From: Dan Grove <dan@grove.cx>
Sent: Thursday, October 6, 2022 3:26 PM
To: Molly McGuire
Subject: Further comment on 6950 Maker/File 2207-019

EAST ELEVATION

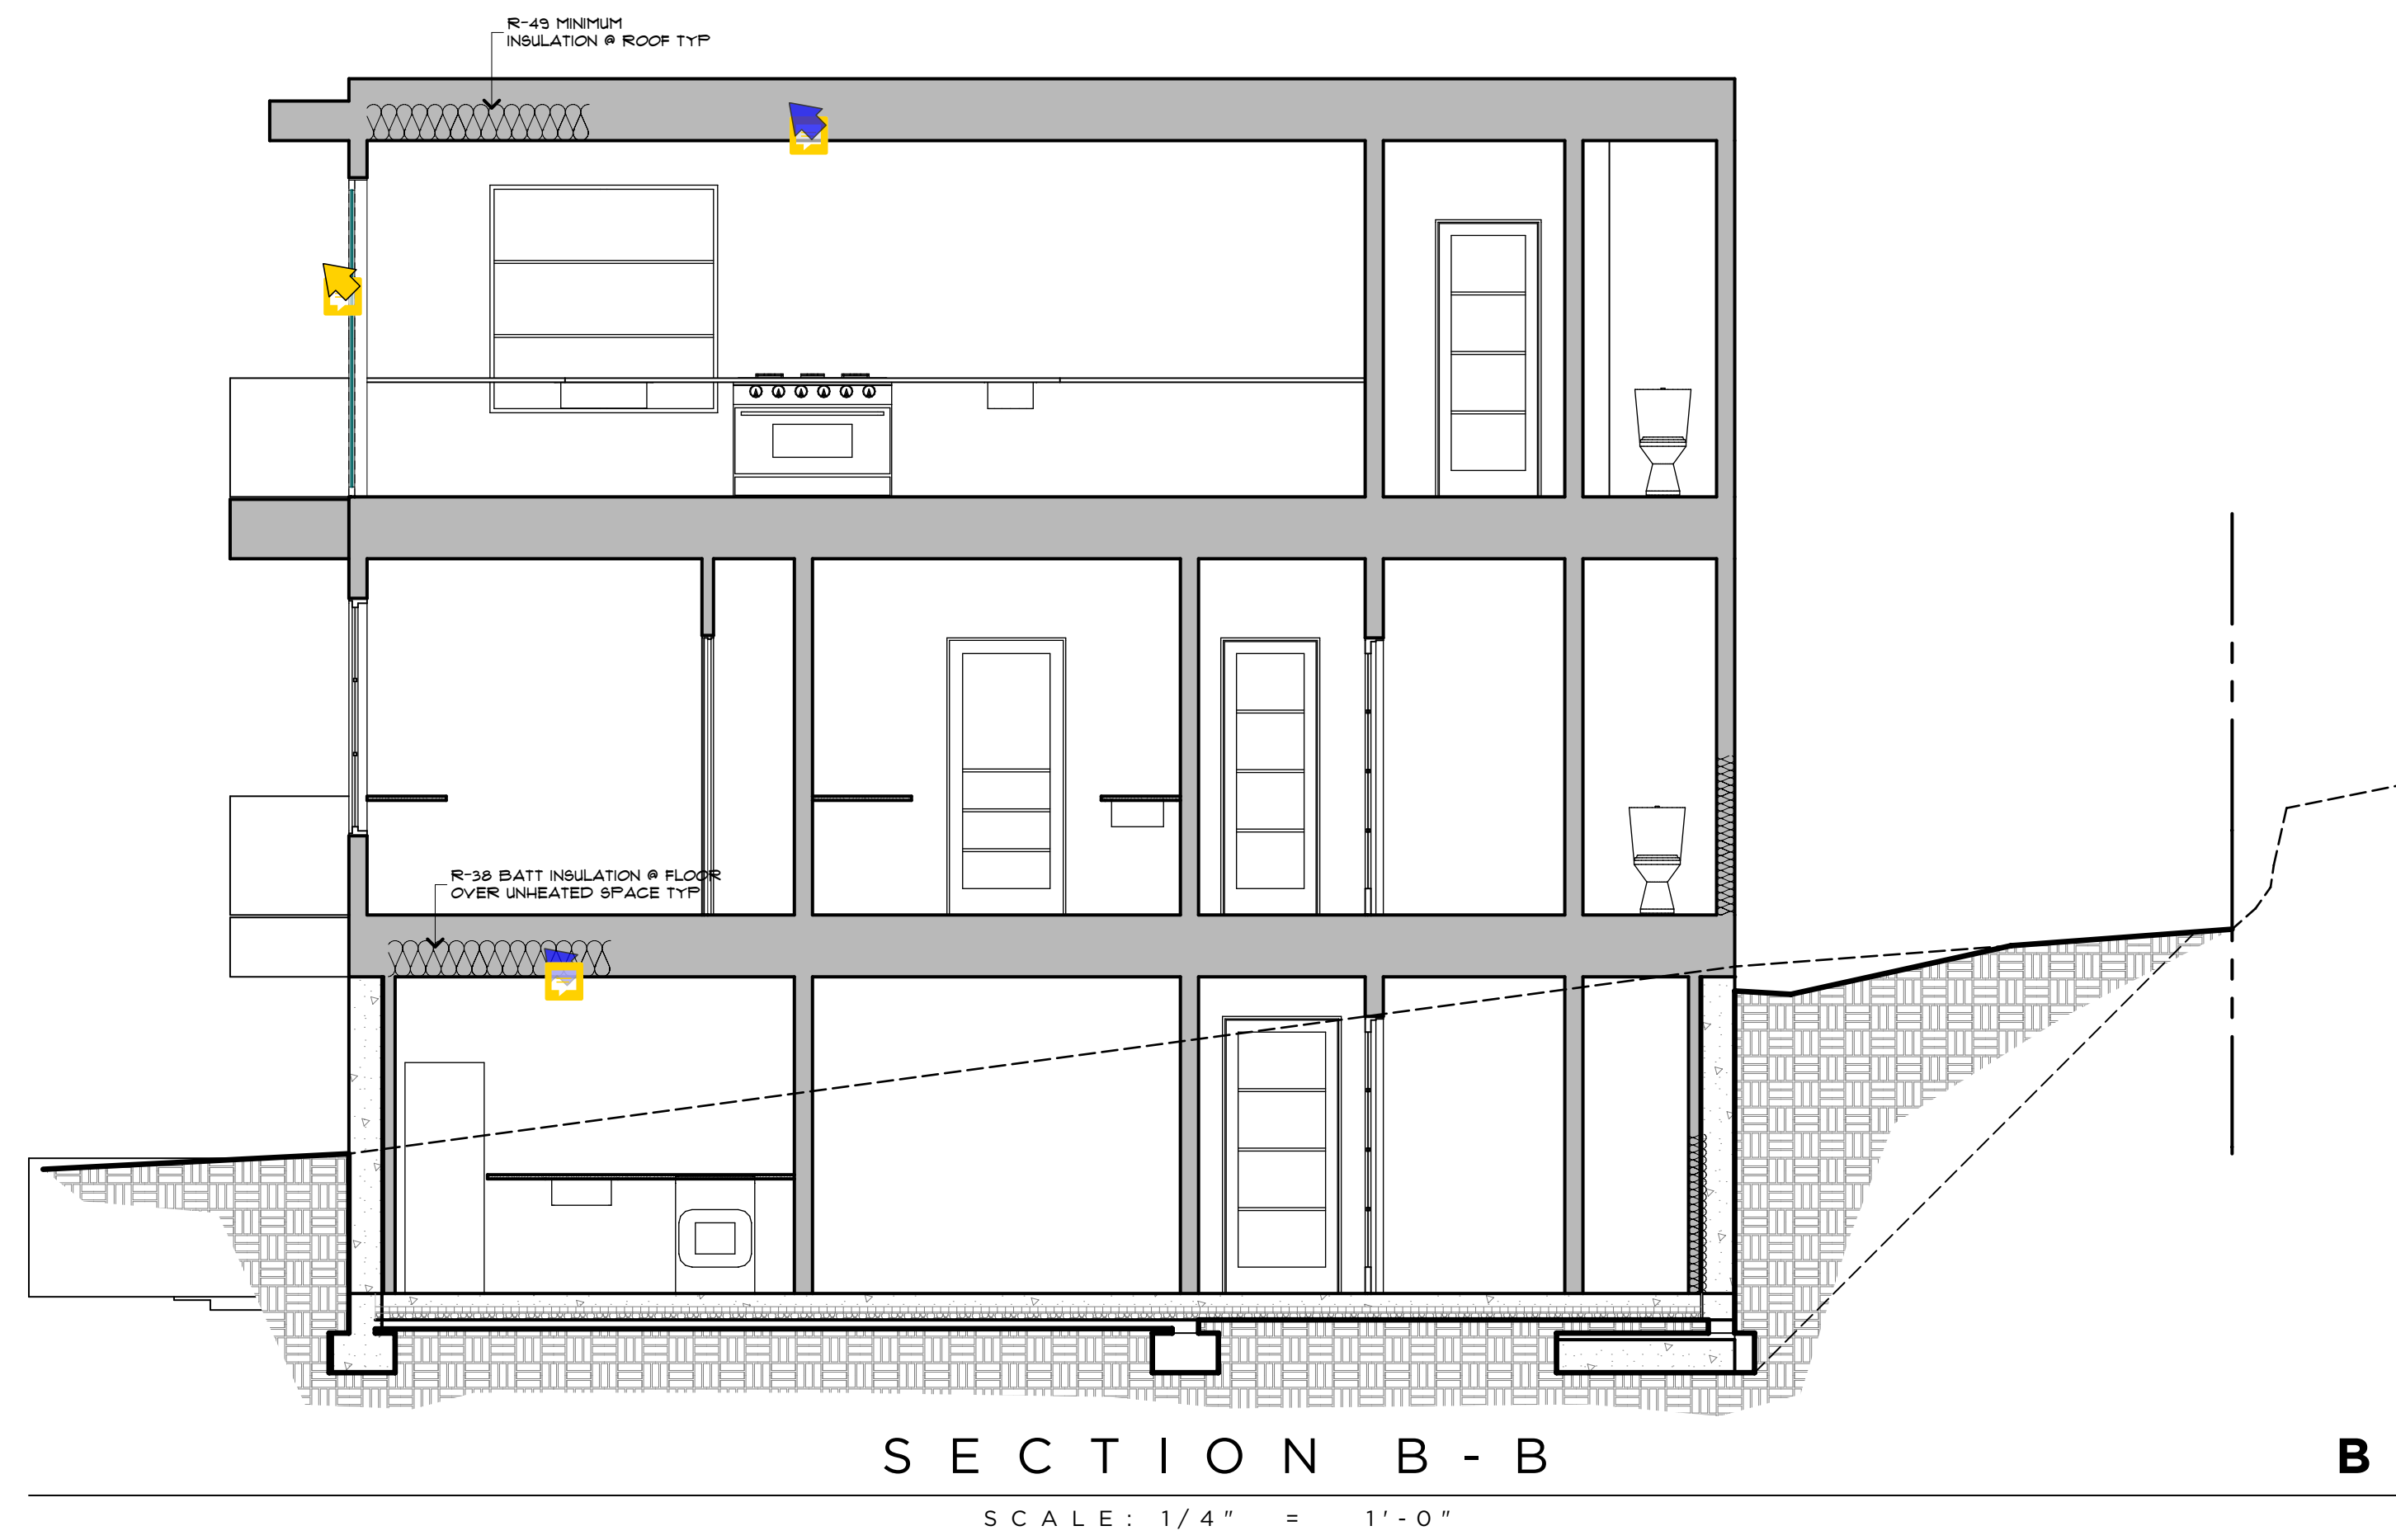
The Project also violates MICC 19.02.020(C).1.c

Sheet A3.1 shows a facade of 26' on the east wall (from an existing grade of 235.24' [sheet A3.1 of plans] to the top of the wall at 261.43' [also sheet A3.1]).

However, 19.02.020(C).1.c:

"Single-family dwellings with a height of more than 25 feet measured from the existing or finished grade, whichever is lower, to the top of the exterior wall facade adjoining the side yard shall provide a minimum side yard depth of ten feet."

Although the facade over 25' doesn't sit less than 10' from the property line, that is not what the code says. The facade adjoining the east side yard is 26.2' feet - therefore, the east yard must have a minimum depth of 10 feet.
